<b>Consultation Response from KC Highways Development Management</b>		
<b>2025/93475 72 Northgate, Huddersfield, HD1 6AE</b>		
<b>Variation of Condition 2 (Plans) on previous permission 2024/92246 for redevelopment of existing site including demolition of existing car sales room (sui generis) and erection of new 2 storey police station (sui generis) with associated car parking, landscaping and infrastructure</b>		
<b>Date Responded:</b> 16/04/26	<b>Responding Officer:</b> M Zenner	<b>Responding Ref:</b> 5-8SE/37

The proposals are for an amendment to the previously approved application for the Police HQ. The submitted proposals appear to amend the access arrangements to incorporate the addition of vehicle barriers on the accesses from Broadway and Lower Fitzwilliam Street. As a result of the works there are also some elements of retaining walls and fencing that are proposed.

Southern Retaining Wall Plan
1 : 100

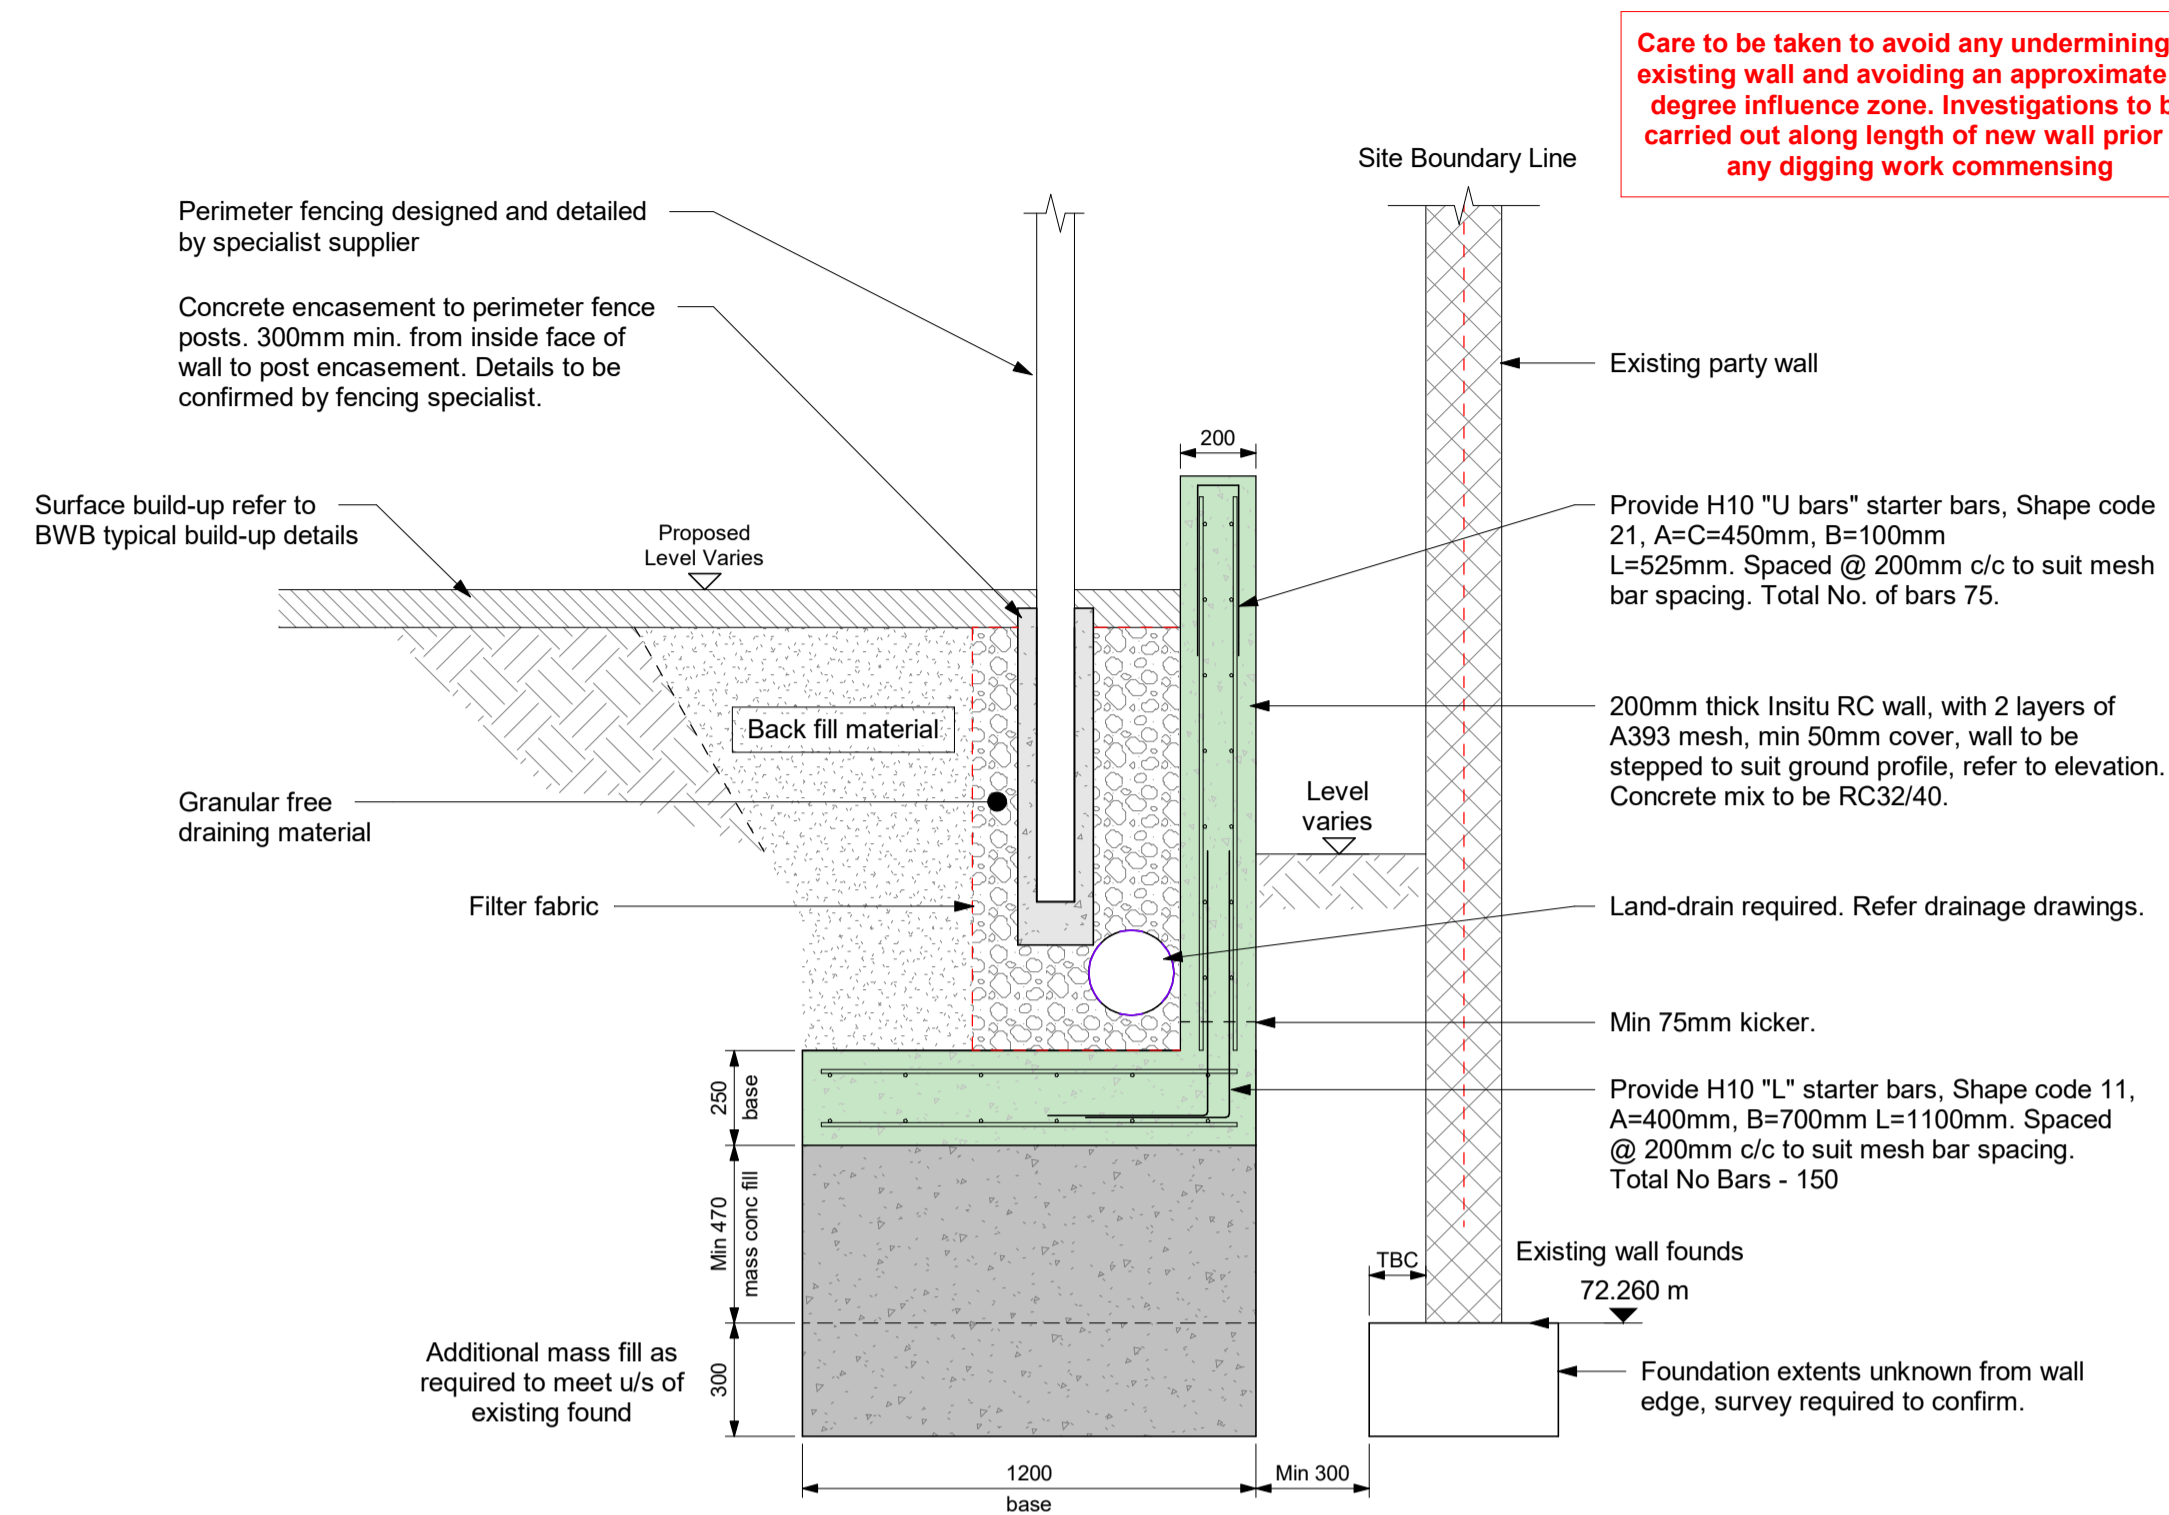
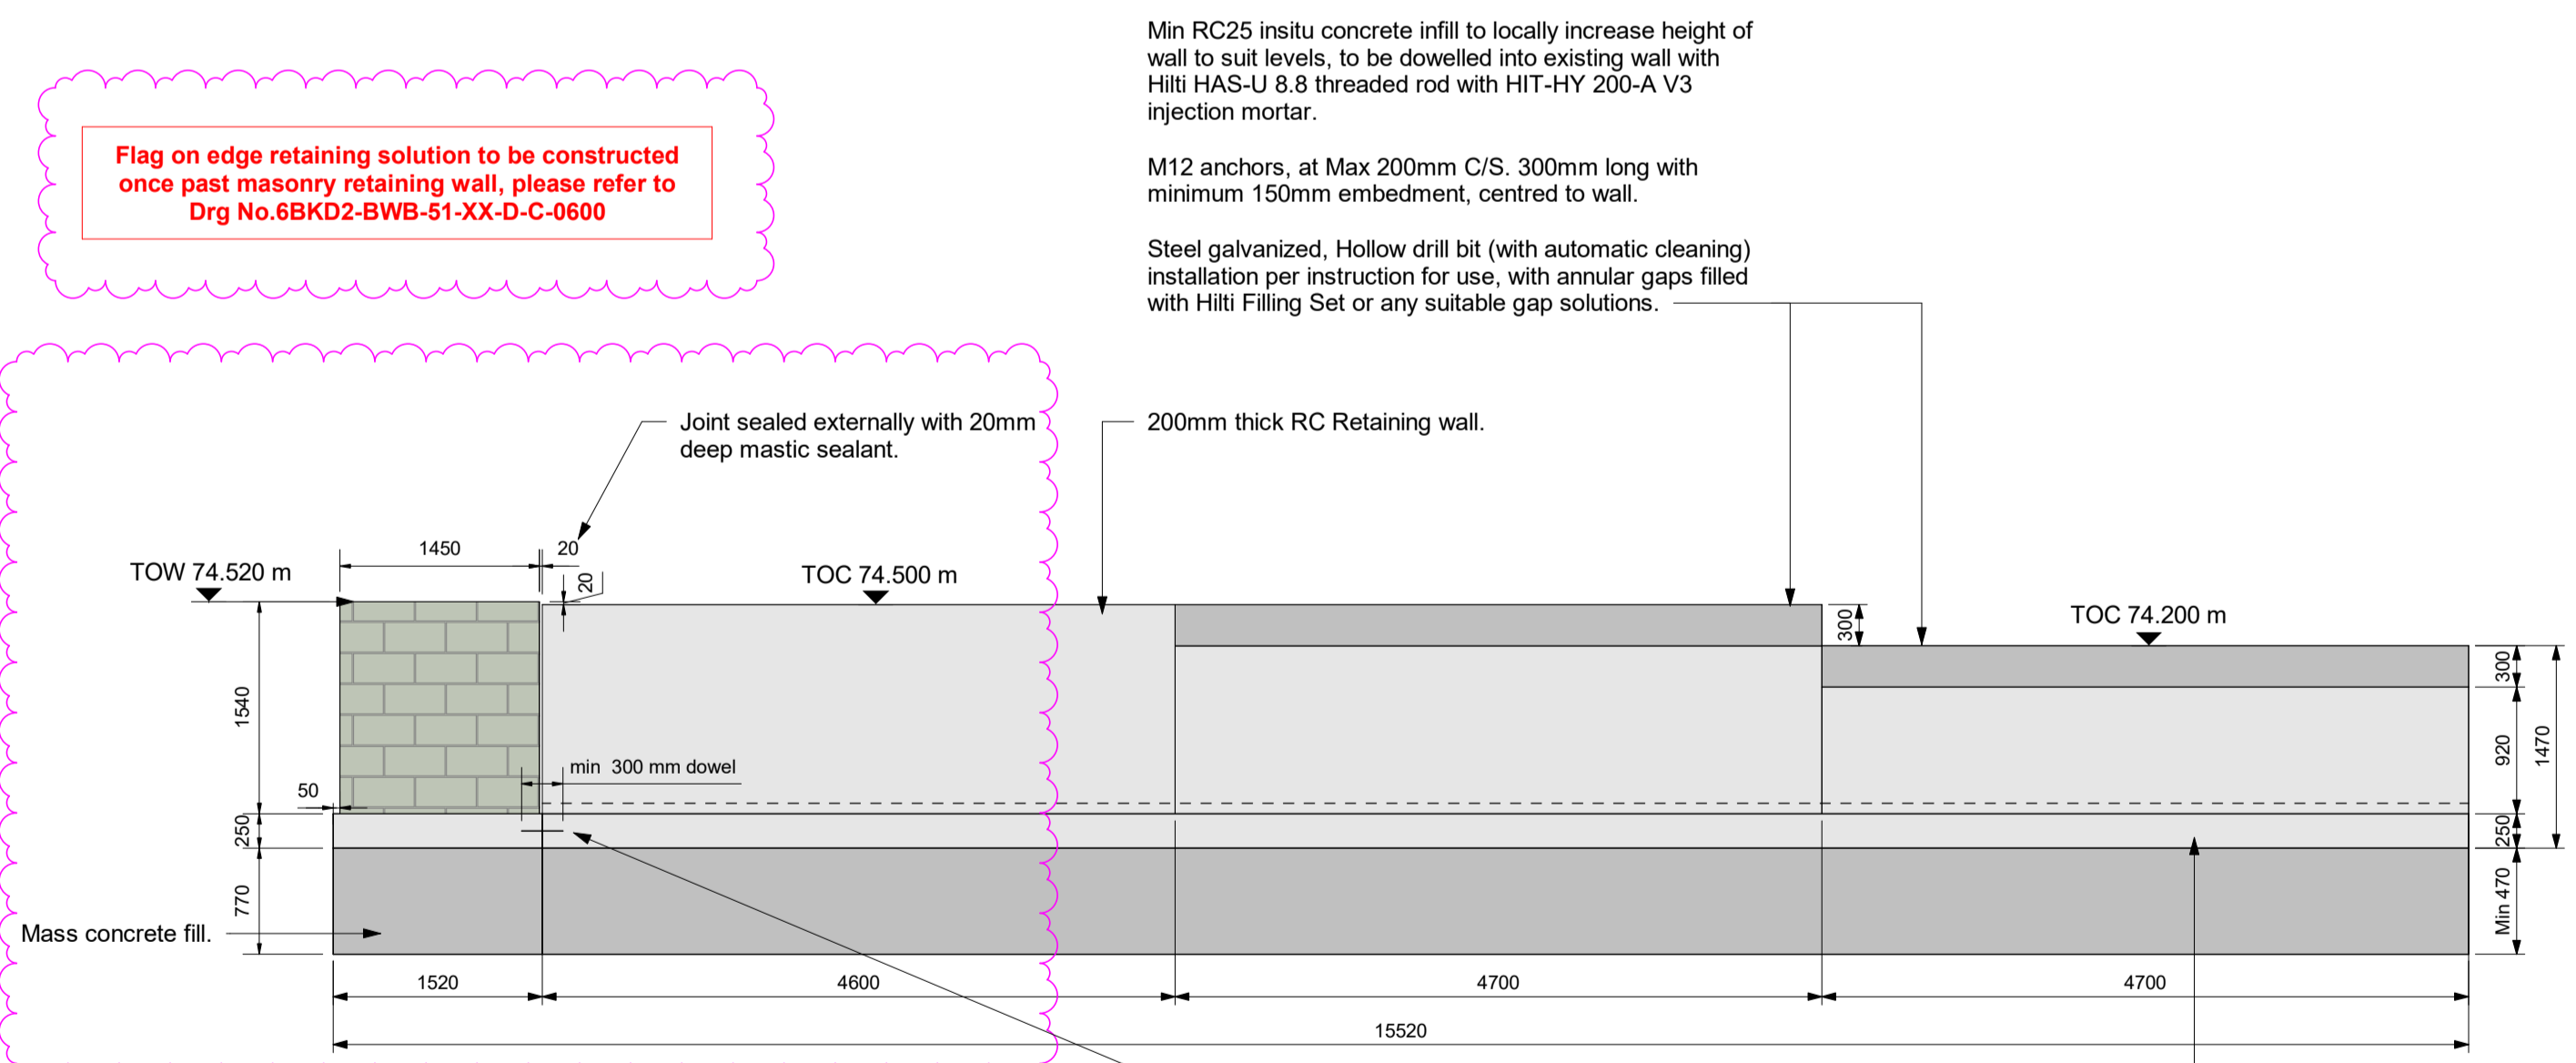
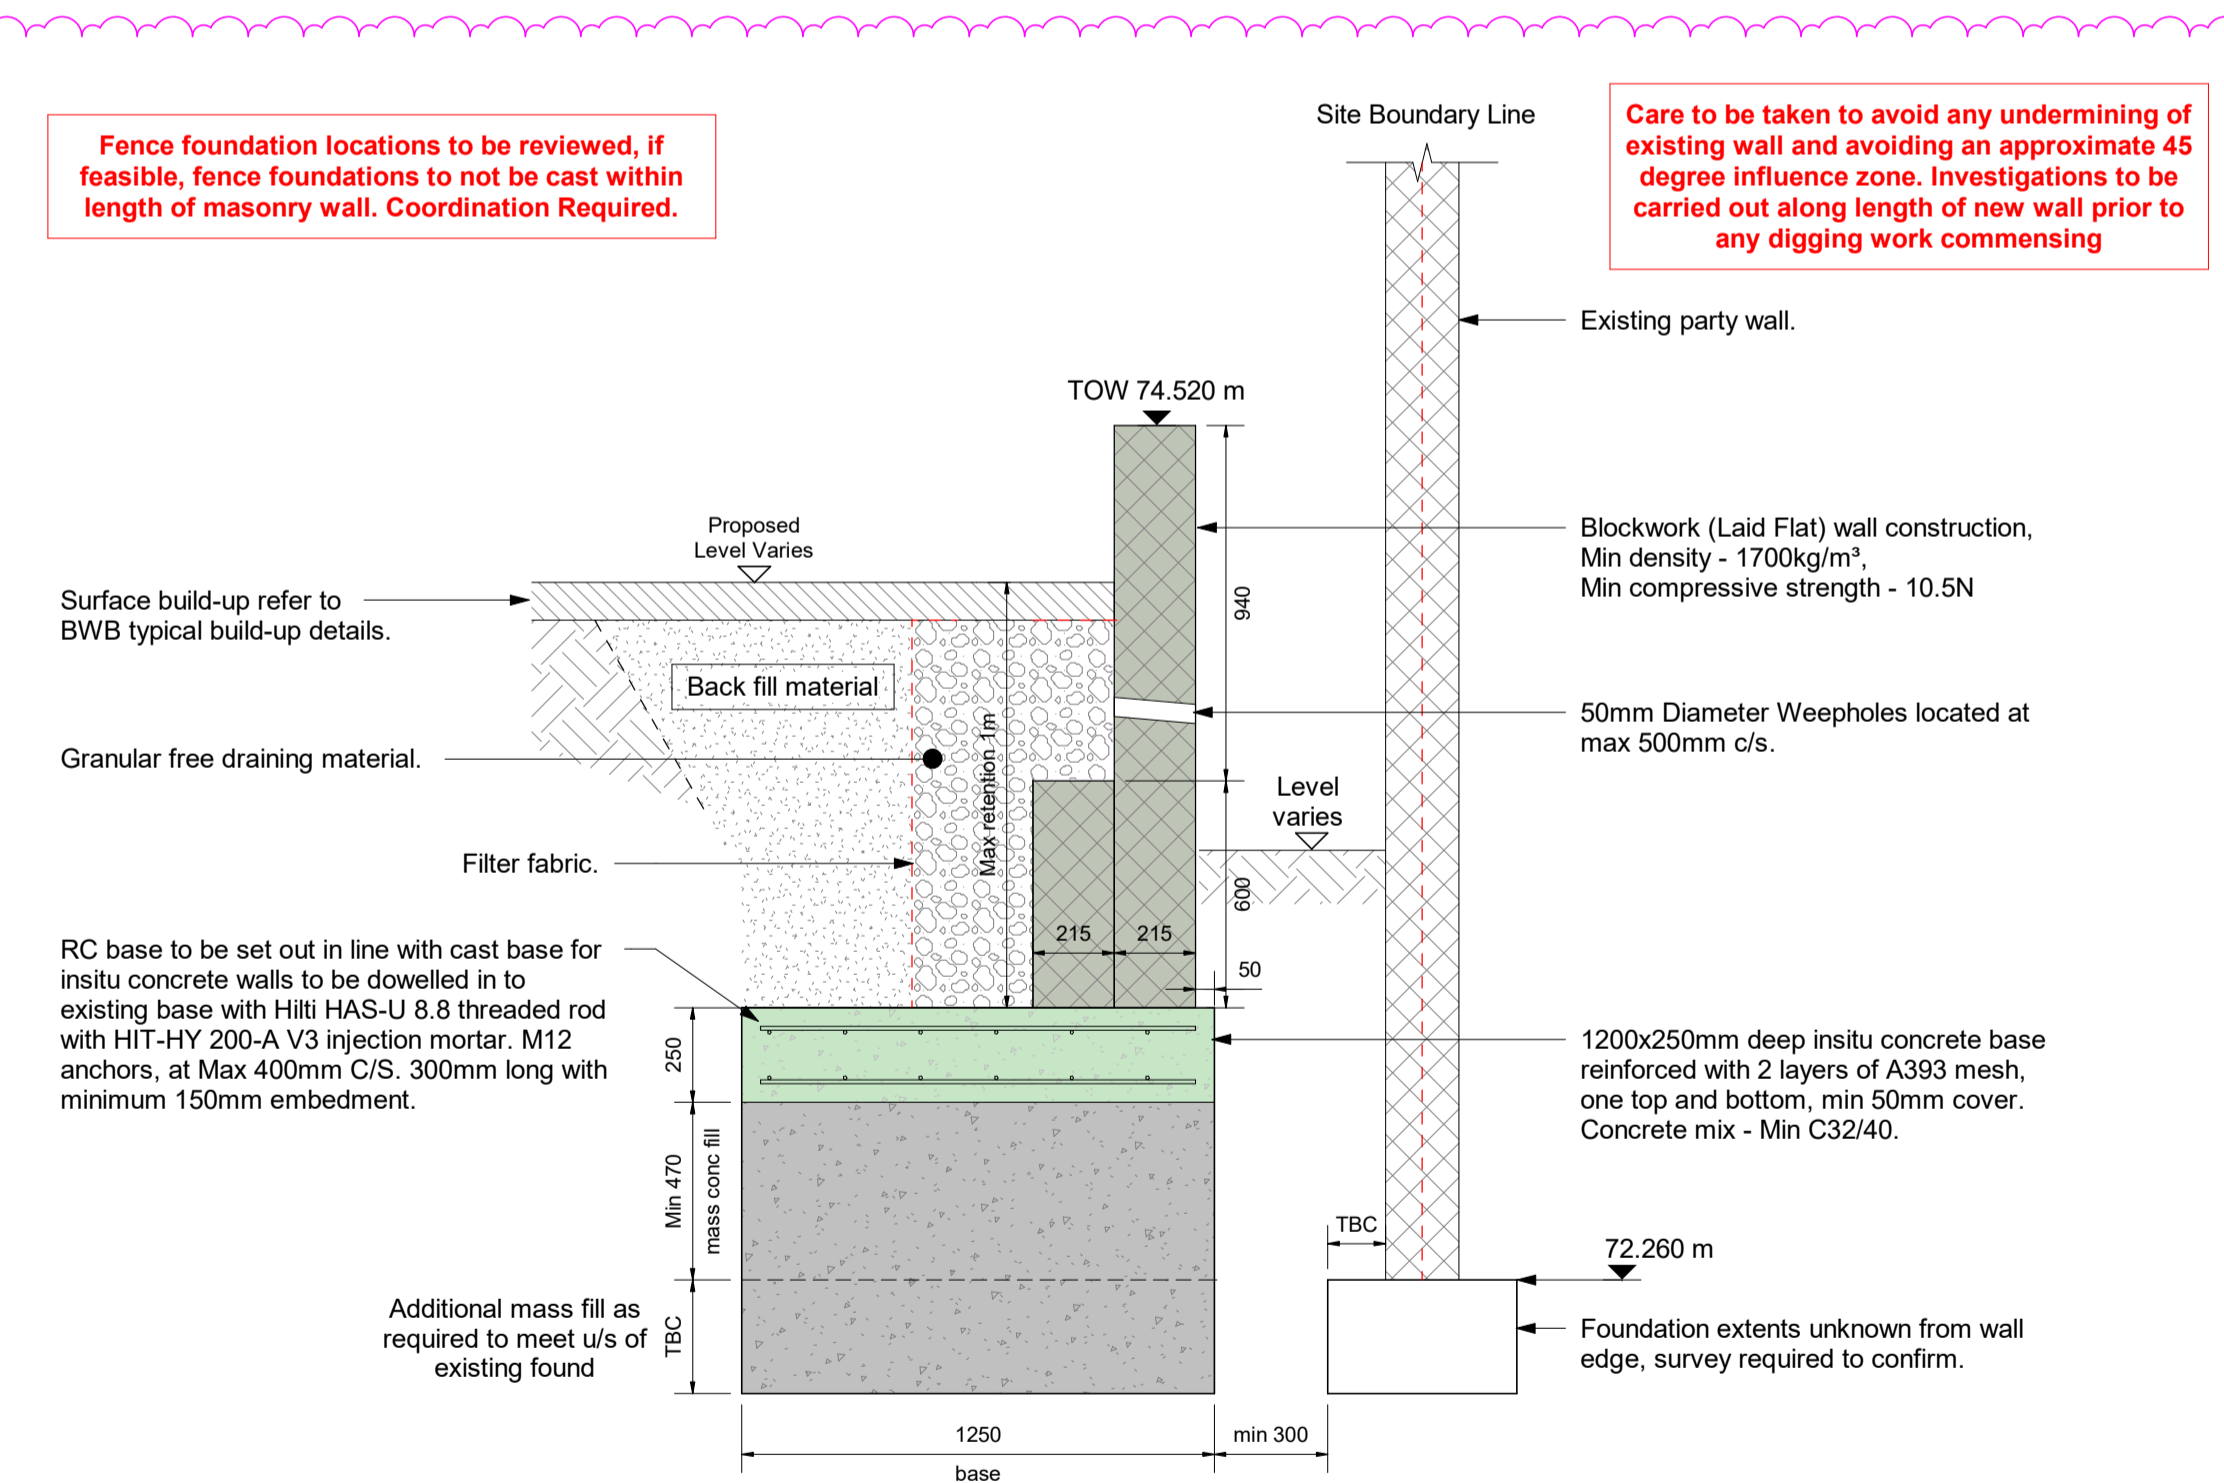
The vehicle access point from Broadway proposes a barrier set back approximately 23m, stop lines on either approach and also a swipe / push button point on approach to the site. There is also the additional of a mesh fencing on the south side of the access and a pedestrian gate to the north side of the access point which seems acceptable.
